Storm Water Compliance Inspection Form

Date: 07-07-2021

Permit Tracking #: NMR1003H1

ESC-2

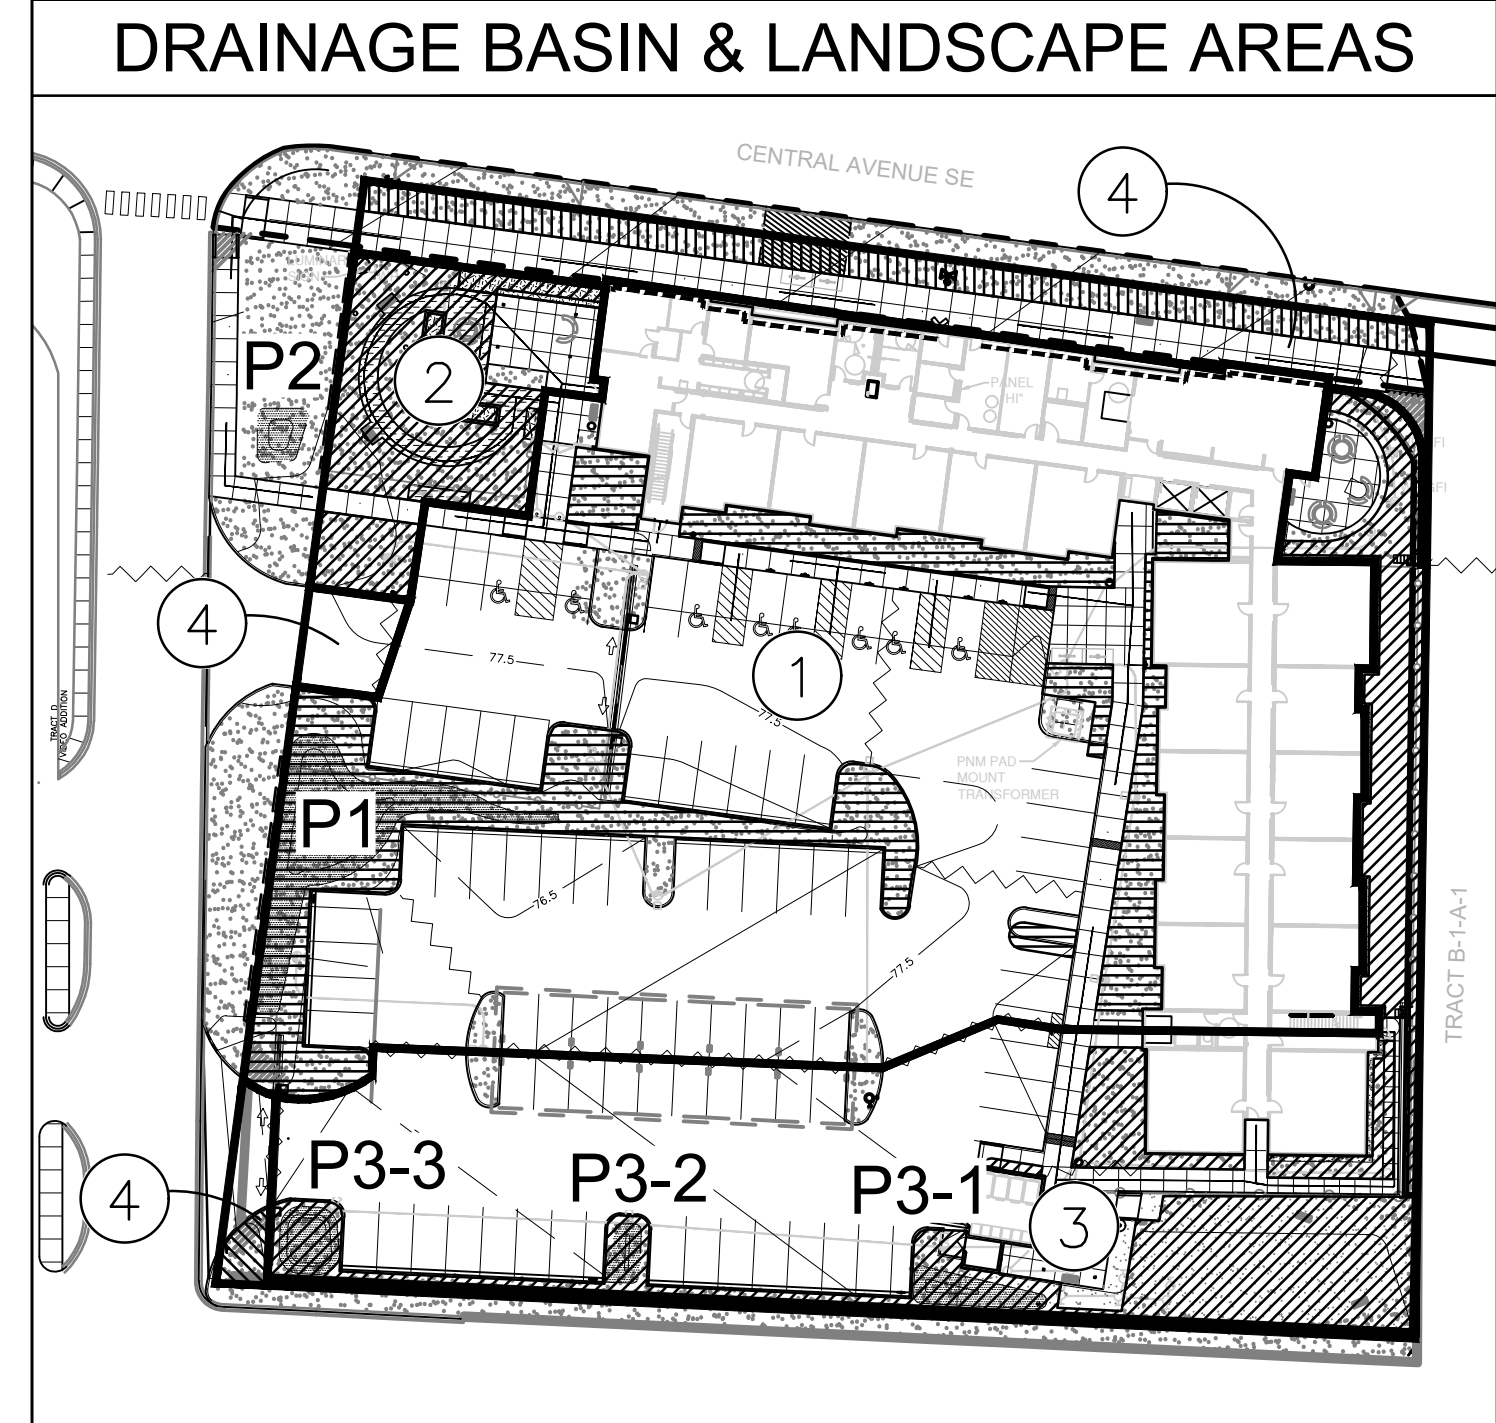
Location	Action Type	Action Required	Date Noted	Date Completed	Initials
North side	Corrective Action	Missing 20' of filter sock along central Ave	07-07-2021		
Concrete washout	Corrective Action	Concrete washout dumped on the ground need to be cleaned up	07-07-2021
